SSD Submission Response

UNSW - Biological Sciences Project
May 21, 2015

prepared for Brookfield Multiplex
by Black Beetle pty ltd

Figure 6 – Figure 5.6a of Randwick Council DCP 2013
 Source: Randwick City Council and Black Beetle

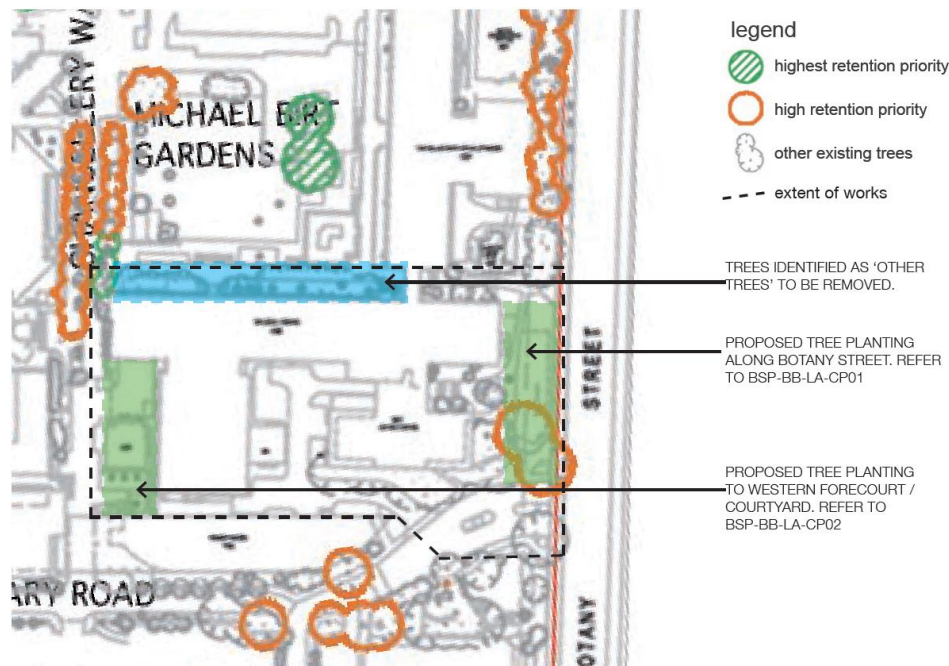
Part 4.2.5 refers to the existing trees to the north-western corner of the Biolink Building (D26) which are identified as 'highest retention priority' as per figure 5.6(a) and the northern portion of the Biolink Building as 'landscape tradition areas - preserve within guidelines' as per figure 5.6(b). The statement of environmental effects and attached arborist report details the removal of 31 trees along the northern portion of the Biolink Building (D26) to accommodate new decking and retail/student services component.

The trees identified as 'highest retention priority' and 'high retention priority' as per figure 5.6a have been retained, trees proposed to be removed are identified as 'other trees'. Note the majority of these trees to be removed are weeds (Umbrella Trees), which can be removed without consent and are classified as invasive environmental weeds.

The proposed selection of palms (*Livistona australis*) to the western courtyard provides a continuation of the existing palms (highlighted as 'high retention priority' in figure 5.6a). It also provides an opportunity to establish a significant grove of palms along the Chancellery Walk, supporting legibility of this entry.

Figure 7 – Proposed Gate 11 landscape treatment

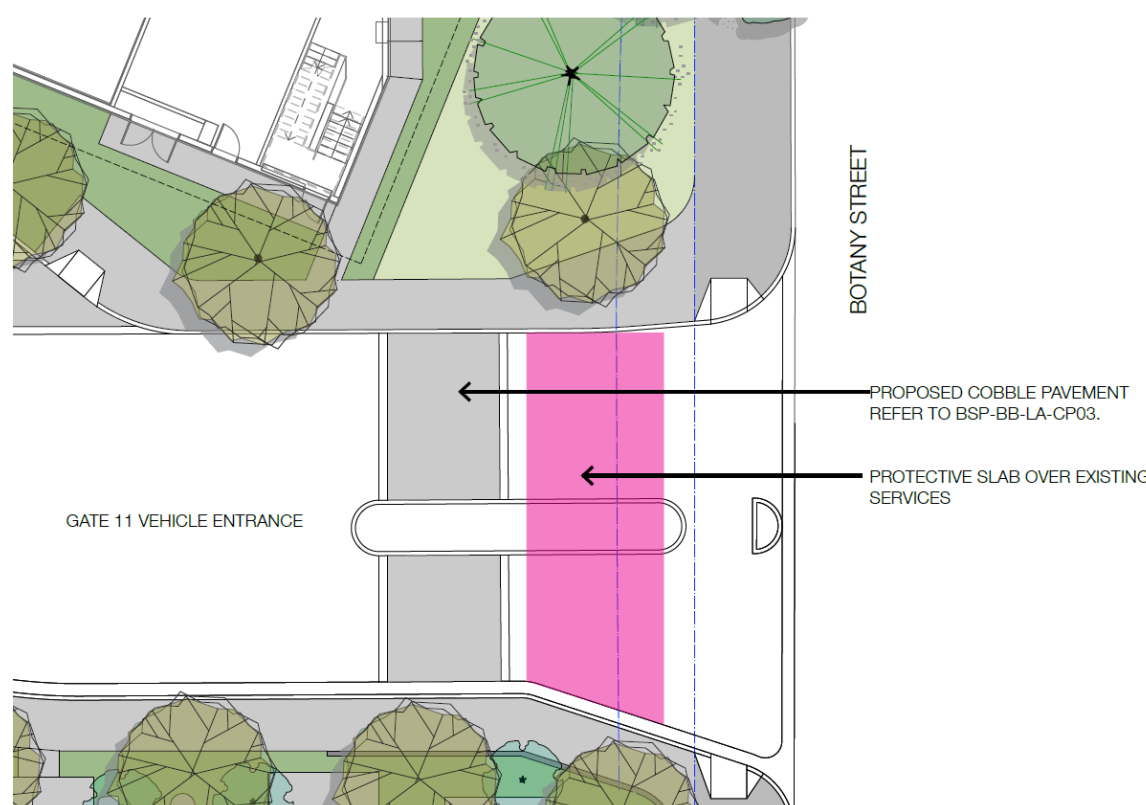
In line with previous suggestions regarding improved legibility and activation of campus gateways at Botany Street, it is recommended that differentiated threshold treatment at Gate 11 is introduced in order to not read as a public road going through the campus, and to provide a continuous and safe pedestrian footpath.

- Cobble crossover at Gate 11 entrance introduced.

A differentiated treatment of cobblestones has been proposed as part of the Gate 11 enabling works to replicate the cobbled pavement at the existing Gate 11. (refer to FIG. 3.0 below). It has also been advised from the structural engineers it can not be brought forward towards Botany Street due to the concrete protective slab to be installed over existing below ground services in this location. The proposed location matches the existing treatment at Gate 2 of the University.
